From:
To: [Neil Bearcroft; DCAdmin](#)
Subject: Objection to application 2020/93467
Date: 23 November 2020 12:19:16

Objection

CLIENT:	
ACUMEN	
JOB TITLE:	
GATEPOSTS AT 402 BIRKBY ROAD, HUDDERSFIELD	
DRAWING TITLE:	
PROPOSED SITE PLAN & ELEVATION	
DRAWN: JF	DATE: Sep
CHECKED: JC	SCALE: 1:200 @ A1
DRAWING NUMBER:	2532 - 12

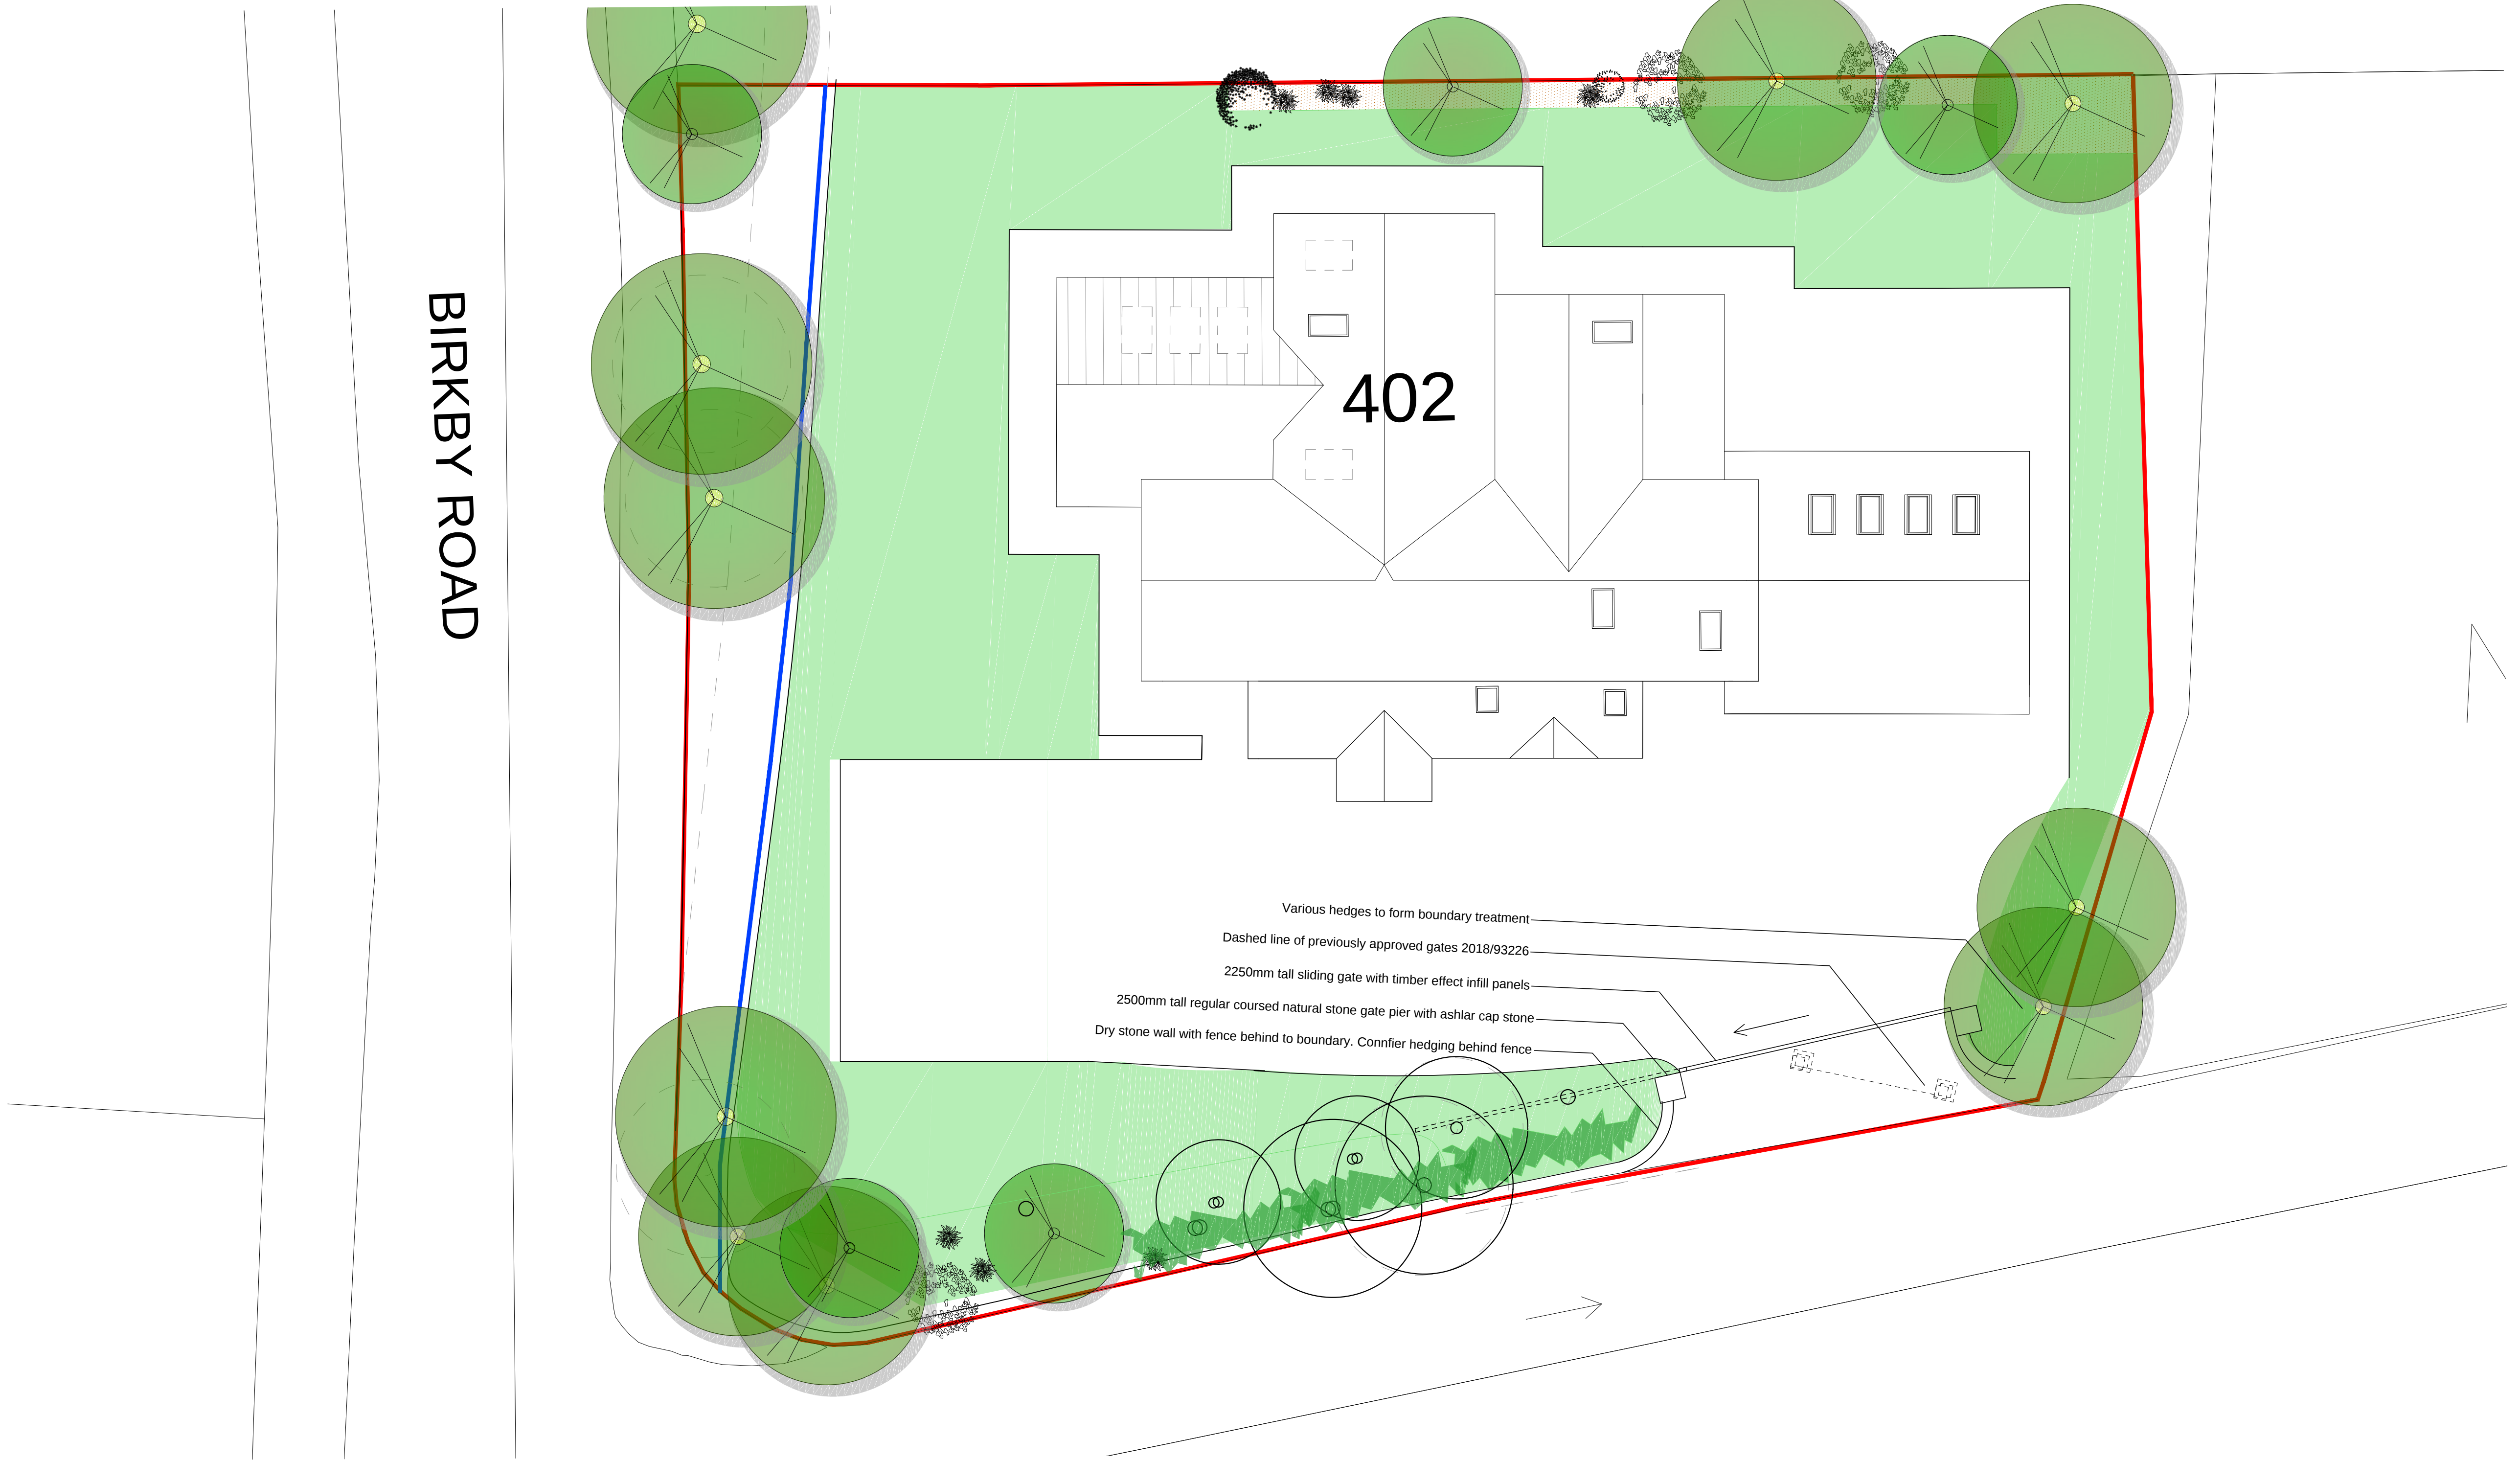
As this retrospective application is for a repositioned and widened gateway and gate the Planning Department should now review and take into consideration vehicular access to the property again. When 402 was originally built the then owner erroneously and without our knowledge stated that our part of our property, a square of land adjacent to our home and the lane, could be used for vehicles to turn in.

Because gate at 402 is never opened fully for deliveries etc to enter these vehicles are then forced further along the private lane to turn in our square. The residents themselves also do so at times. All turning for any vehicle to do with 402 should take place within its own curtilage and the access requirements to achieve this can now be addressed by Planning now there is an application for a new repositioned and enlarged gateway and posts

The oversize gate and fence that have been installed at 402 are enormous and not at all in keeping with the street-scene of other five properties that use the lane. They also exceed the 1m maximum height legislation for fences next to a 'highway'. It has been pointed out to us that a Kirklees planning portal statement includes unadopted and private ways in the definition of a 'highway' for the purpose of the order.
